Revise interior partition layout and provide two new doors as shown to eliminate two conference rooms & create an open office area as shown.

Revise location and layout of Server Rm. as shown. Delete Office Storage Rm. and add Conference Rm. as shown.

FIRST FLOOR SPRINKLER PLAN
2009 RECORD DRAWINGS

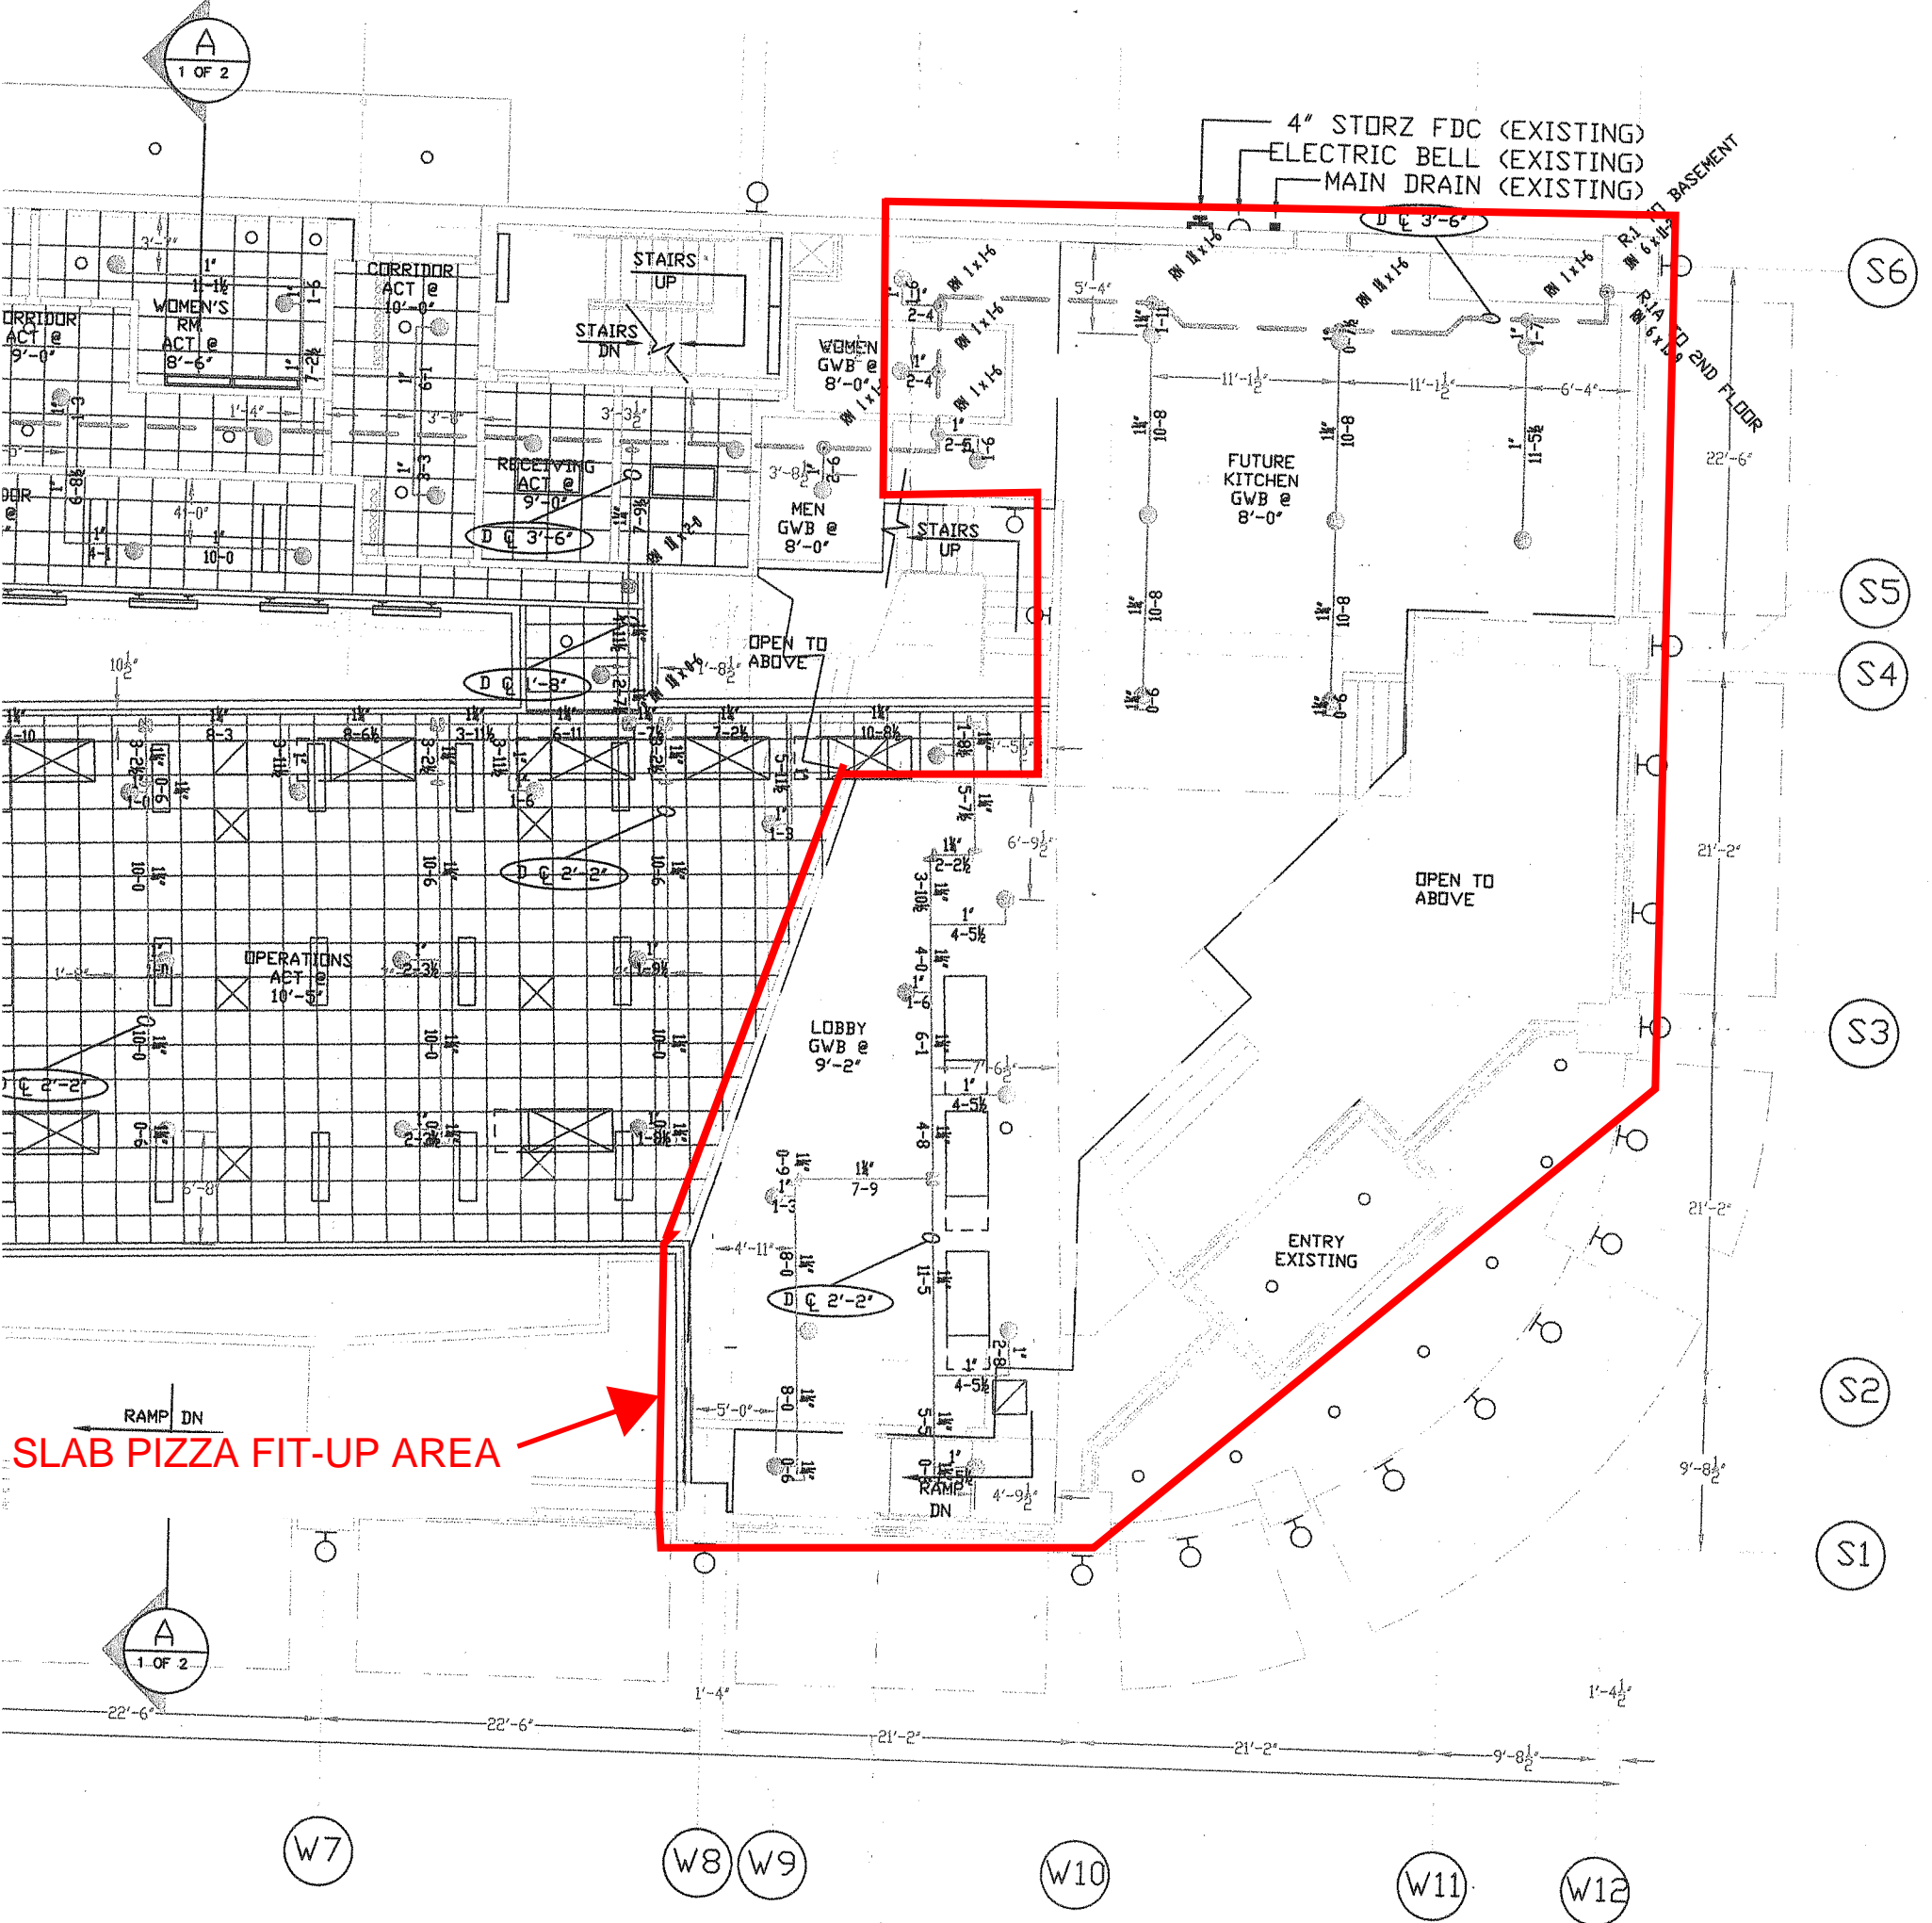
NO ELECTRICAL CONDUITS, MECHANICAL PIPING OR SPRINKLER PIPING SHALL BE RUN OVER THE SERVER ROOM. EXIST'G SPRINKLER MAIN SHOULD BE RELOCATED TO RUN AROUND THE RM. INSTEAD OF DIRECTLY OVER IT.
